Please ask for: Mrs D Johnson
Email: daun.johnson@arun.gov.uk
Telephone: 01903 737762
Our Ref: FP/132/20/PL
Your Ref:
Date: 10th August 2020

Application for Planning Permission

Development: Change of use from land at golf course (D2 Assembly or Leisure) to garden land in connection with dwelling. This application is in CIL Zone 4 (Zero Rated) as 'other development'.

Location: 3 Mid Acre Close Felpham PO22 8JU

Drawing Title:
PROPOSED SITE PLAN

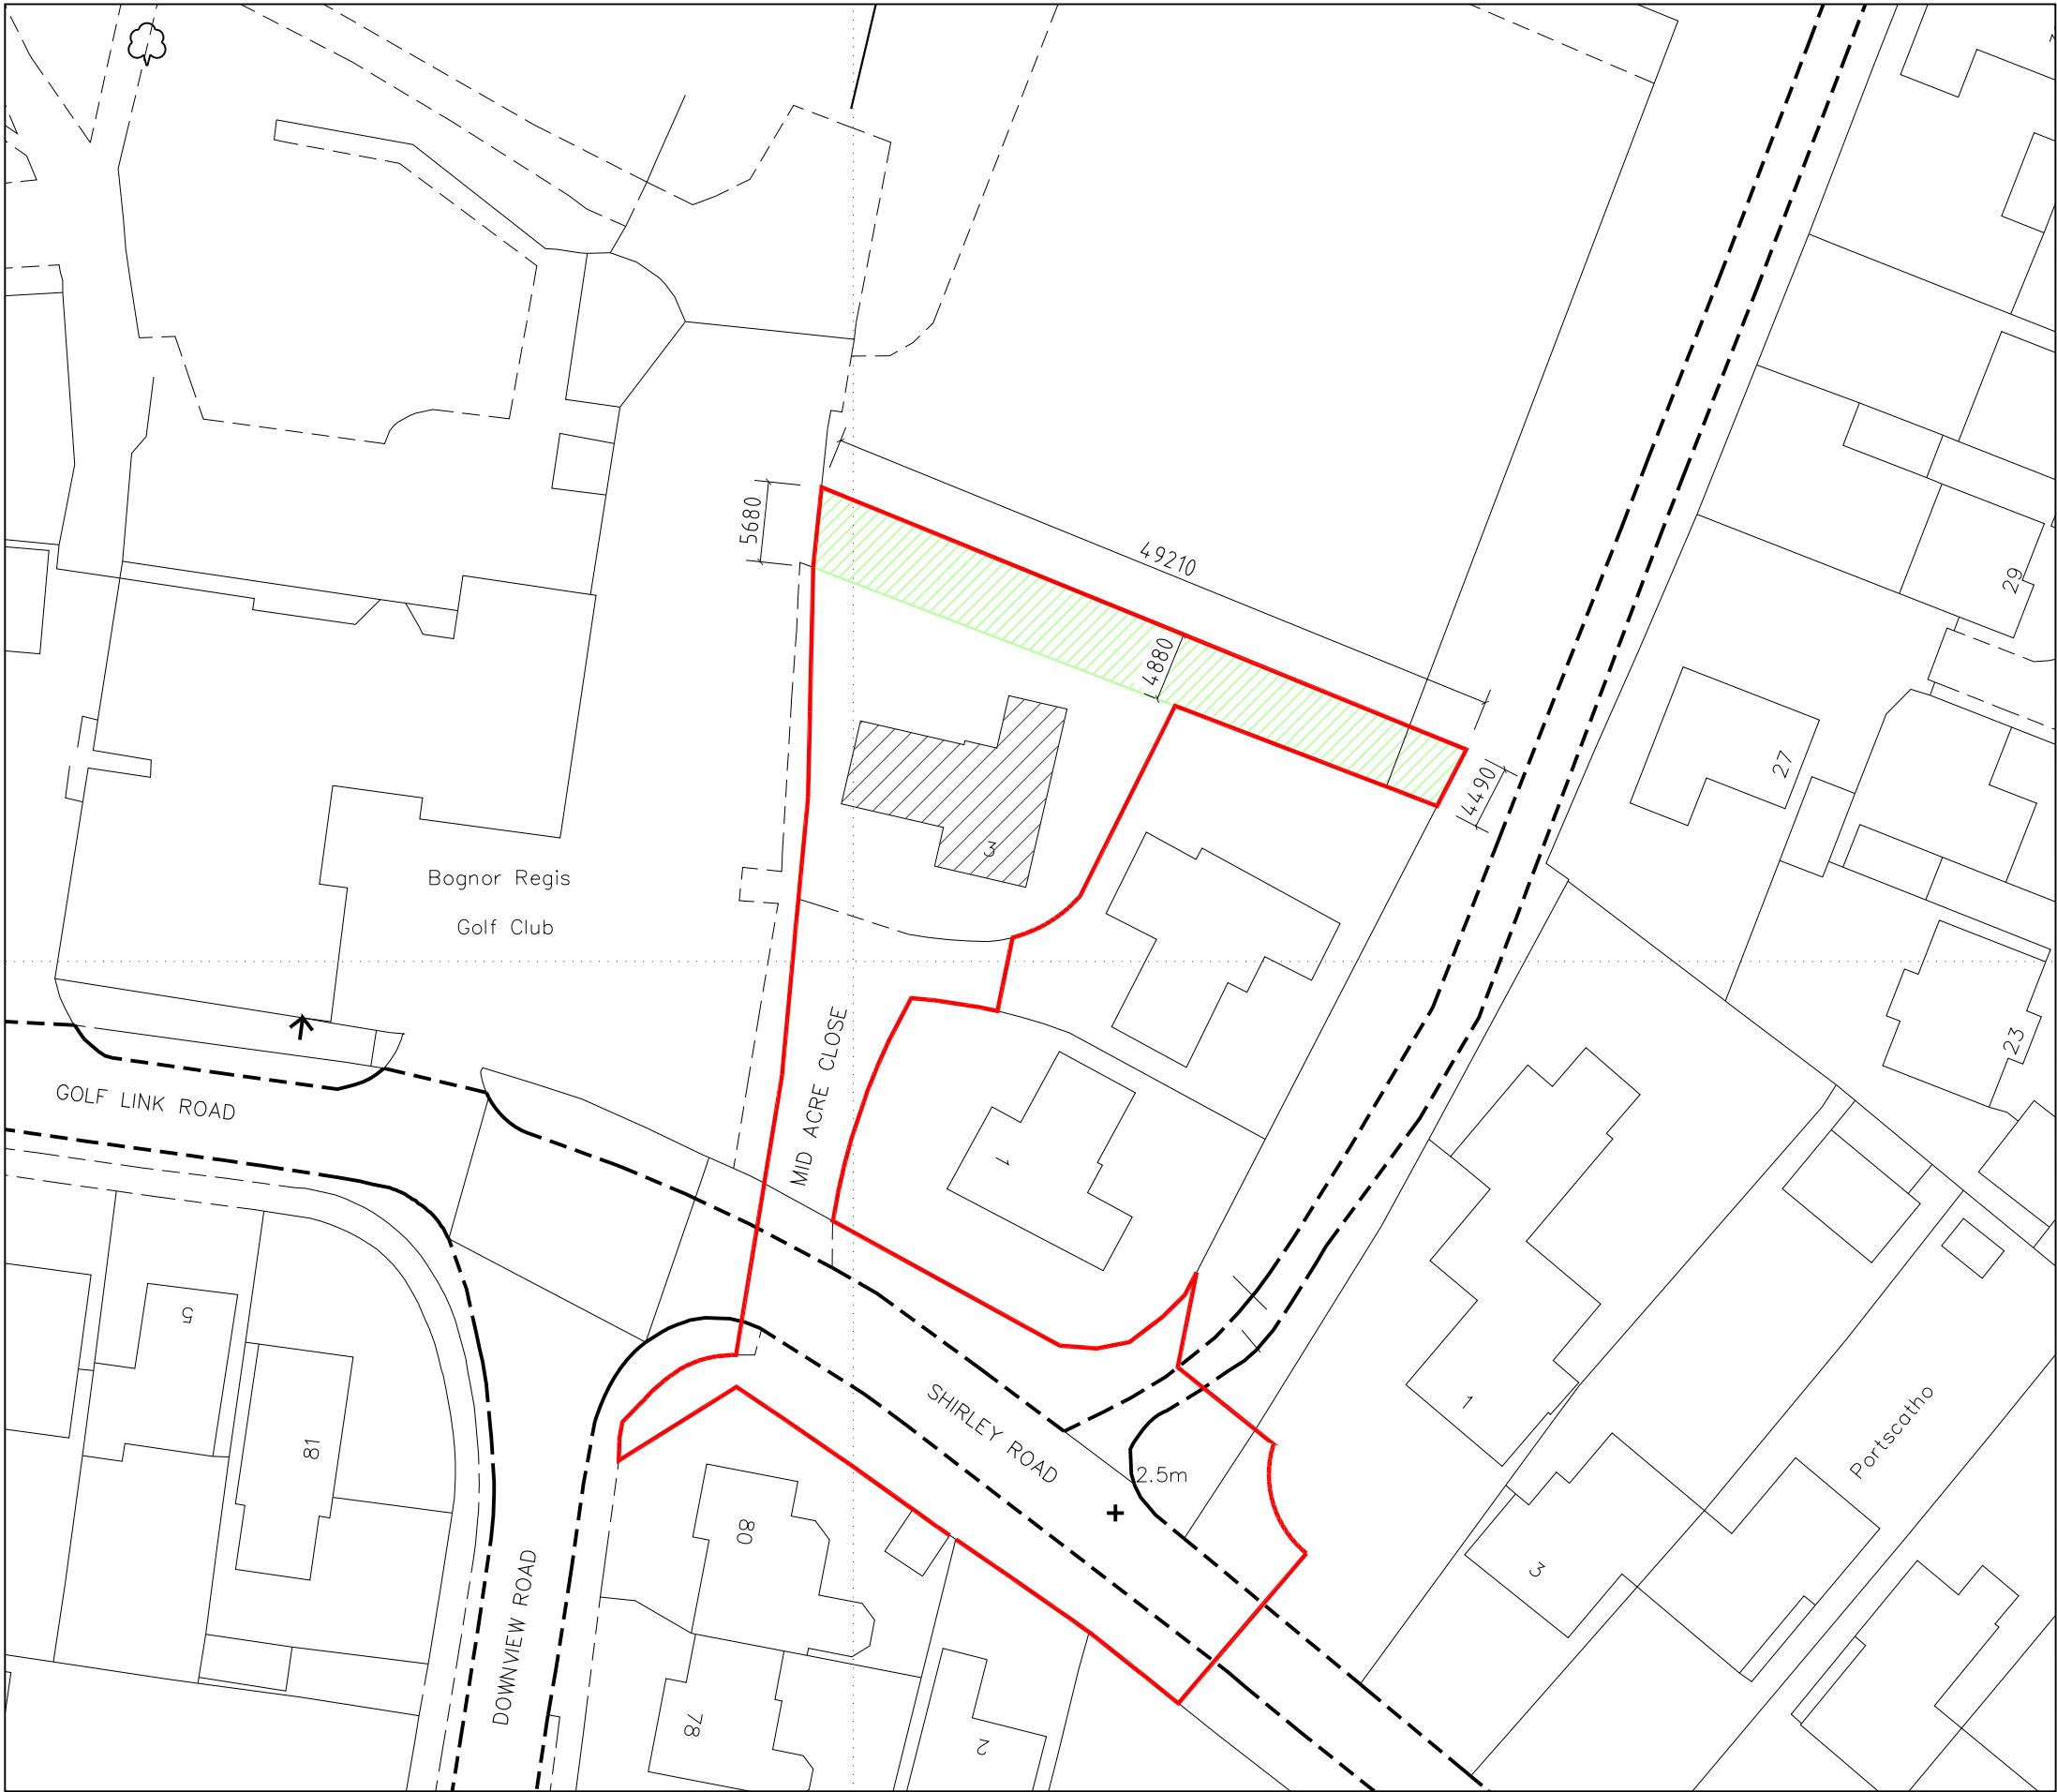
On the proposed block plan, please clearly highlight the proposal
